A1 Birtley to Coal House

Scheme Number: TR010031

Statement of Common Ground with Gateshead Council

**STATEMENT OF COMMON GROUND
WITH GATESHEAD COUNCIL**

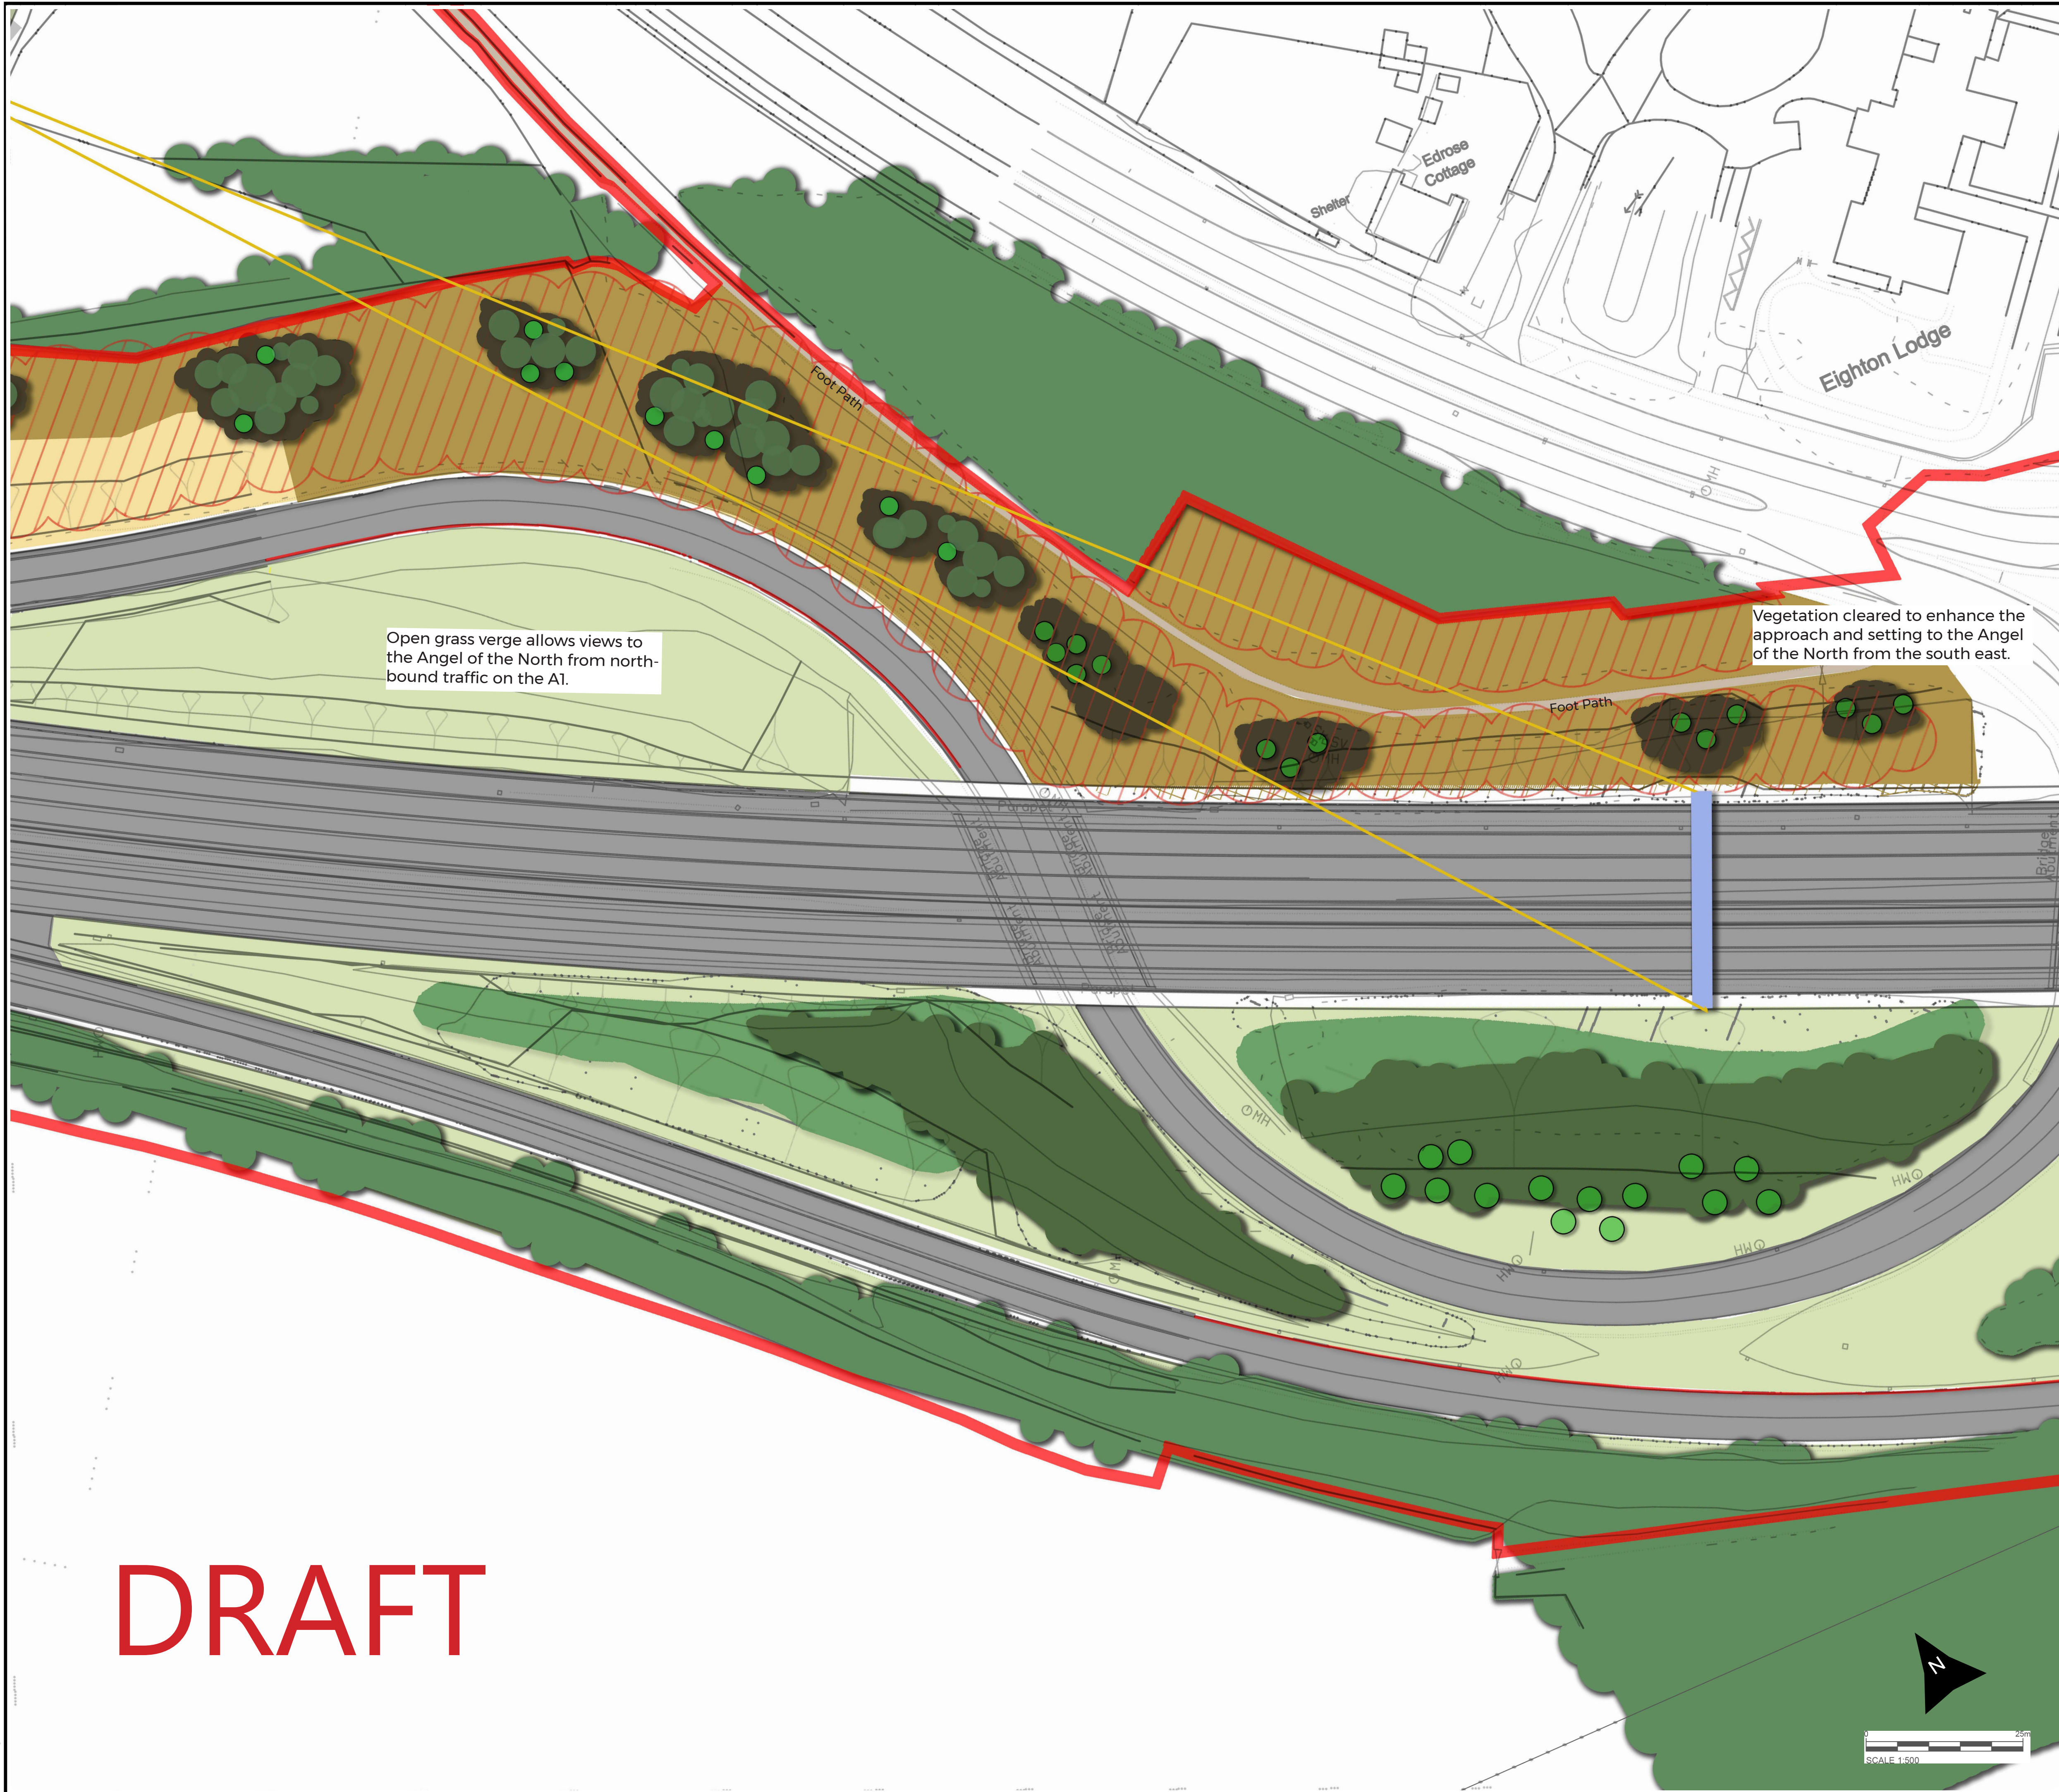
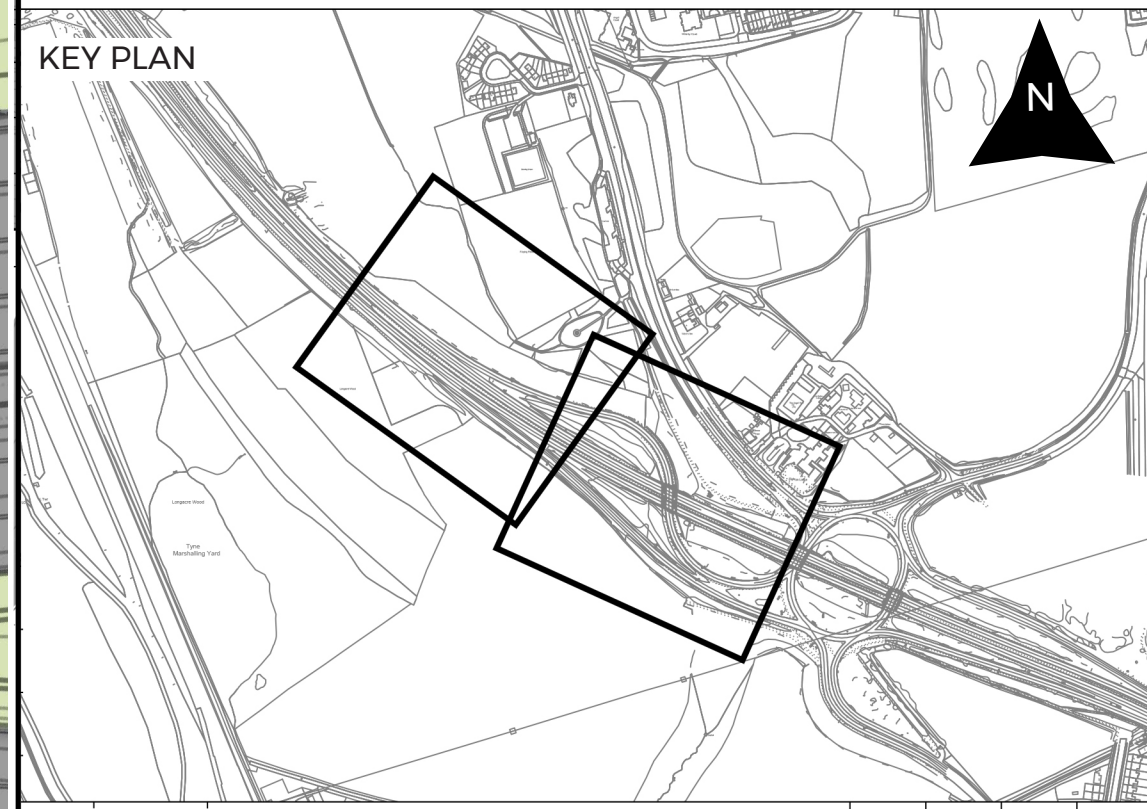
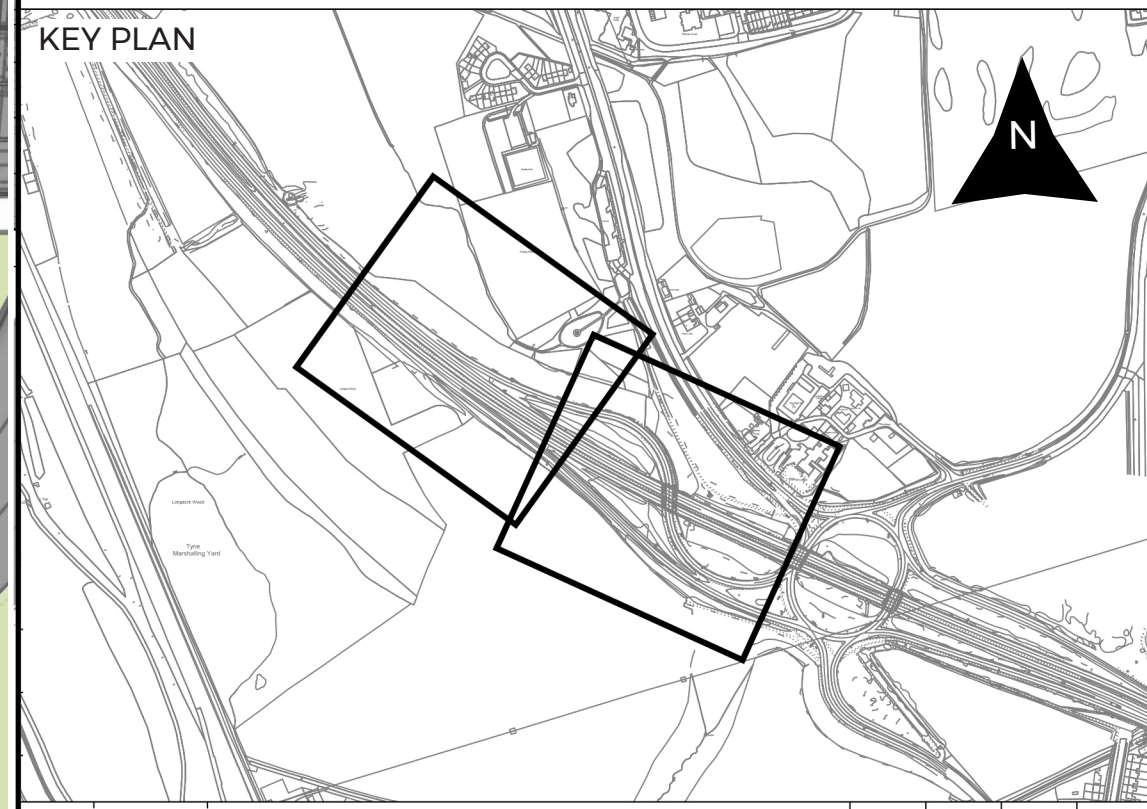
Section	Sub-section	Gateshead Council Position	Highways England Position	Status
Environmental Statement - Chapter 6: Cultural Heritage	6.8 Potential impacts	<p>At a meeting on Thursday 4 June 2020, Gateshead Council advised that they find the revised landscape mitigation plan around the Angel of the North [REP5-005] broadly acceptable, and this was confirmed in an email on the 8/6/20.</p> <p>At a subsequent meeting on the 3/7/20, Gateshead Council confirmed that their position remains that the preferred option from the Southern Green Report [REP4-086] is Option 3 – Revealing the Angel, however, they are happy to continue discussions, with the Applicant outside of the examination period, in order to deliver this through into the detailed design stage.</p>	<p>Following a meeting on the 3/7/20, it was confirmed that the landscape strategy, as set out in Figure 7.6: Landscape Mitigation Design [APP-061] would remain the current design, any changes that are agreed following further, without prejudice discussions, would be undertaken during the detailed design phase, and be subject to agreement with Gateshead Council. Any changes to the design will ensure that the impact assessment detailed within Chapter 8: Biodiversity of the ES [APP-029] and Chapter 7: Landscape and visual of the ES [APP-028] will remain valid.</p>	Agreed

<p>Gateshead Council recognises tensions between artist, climate change and ecology views. Gateshead Council requested visuals of the proposed A1 works showing the landscape in its finished (post construction) massing would assist in developing the detailed landscape design and</p>	<p>During a meeting in the 3/7/20 it was agreed that until such time as there is further discussions and agreement on the proposed changes associated with the Angel of the North location, the current landscape design, set out in Figure 7.6: Landscape Mitigation Design</p>	Agreed

Section	Sub-section	Gateshead Council Position	Highways England Position	Status
		<p>enable views to be managed alongside gantries and other infrastructure.</p> <p>Agreed in November 2019 that a single joint landscaping scheme should be developed by Highways England and Gateshead Council.</p> <p>At a meeting on the 3/7/20, Gateshead Council confirmed that their position remains that the preferred option from the Southern Green Report [REP4-086] is Option 3 – Revealing the Angel, and that they were happy to continue discussions with the Applicant in order to deliver this through into the detailed design stage. However, until such time the current landscape design, set out in Figure 7.6: Landscape Mitigation Design [APP-061] remains the current design agreed within the DCO examination.</p>	<p>[APP-061] remains the current design agreed within the DCO examination.</p> <p>During the meeting a number of points were discussed on how the design could be taken forward and the constraints and opportunities that may influence the final design, not least that there should be not additional financial cost to the Applicant in delivering the aspirations of Gateshead Council, and these are outline below.</p> <p>It is confirmed that the Gateshead Council and the Applicant continue to make progress on their discussions on how the Scheme could support the aspirations of the Council in making changes to the landscape around the Angel of the North, in removing some of the established trees and shrubs and increasing visibility of the Angel of the North within views from the A1.</p>

Section	Sub-section	Gateshead Council Position	Highways England Position	Status
		<p>7.6: Landscape Mitigation Design [APP-061] remains the current design agreed within the DCO examination.</p>	<p>Following a discussion on 3 July 2020 it was agreed that:</p> <ul style="list-style-type: none"> • Replacing removed planting within an area to the south of the Allerdene Bridge crossing was undesirable, due to the proposed location's suitability for wading birds. • An off-site location, proposed by Gateshead Council, is therefore preferred, subject to further discussion and agreement; the mechanism for funding this is still to be investigated and agreed. • The preferred option for Gateshead Council remains Option 3 within the Options Appraisal for Managing and Enhancing the Angel [REP4-086], prepared on behalf of Gateshead Council by Southern Green, and the Applicant may support this aspiration, inasmuch as it does not increase costs to construct and manage the landscape within the Scheme, and that the findings of the Environmental Impact Assessment are not affected. • The final agreement is unlikely to be achieved within the Development Consent Order (DCO) examination

Section	Sub-section	Gateshead Council Position	Highways England Position	Status
			<p>period and will be subject to further discussions during the detailed design phase. The landscape mitigation design as set out in Figure 7.6: Landscape Mitigation Design [APP-061] remains the current design. Therefore, and as set out in Appendix A - ISH2 Hearing Actions Landscape, submitted at Deadline 9 [EXA/D9/004] – the Scheme habitat calculations as set out in Table 8-17 of Chapter 8: Biodiversity of the ES [APP-029] remain valid. Should Option 1 of the Options Appraisal for Managing and Enhancing the Angel [REP4-086], prepared on behalf of Gateshead Council by Southern Green, be progressed, this closely resembles the current Figure 7.6: Landscape Mitigation Design of the ES [APP-061]. Therefore, this would not result in any deviations from the existing habitat calculations within Table 8-17 of Chapter 8: Biodiversity of the ES [APP-029].</p> <p>As off site planting locations and areas are yet to be secured in relation to Options 2 and 3, habitat calculations have not yet been able to be finalised. However, Options 2 and 3 of the</p>

Section	Sub-section	Gateshead Council Position	Highways England Position	Status
			<p>Options Appraisal for Managing and Enhancing the Angel [REP4-086], prepared on behalf of Gateshead Council by Southern Green, would result in a similar alteration and reduction of woodland planting within the Order limits, ranging between approximately 8500m² and 9900m² respectively, depending upon which option is developed, and the extent to which woodland may still be included within the Order limits, resulting in the requirement for off-site planting</p> <p>Without prejudice discussions regarding the landscape mitigation design and habitat calculations will continue in relation to the potential changes associated with the Angel of the North. It is the Applicant's position that any changes to the design – including those to accommodate Southern Green Options 1, 2 or 3, must ensure that the impact assessment detailed within Chapter 8: Biodiversity of the ES [APP-029] and Chapter 7: Landscape and Visual of the ES [APP-028] will remain valid.</p>
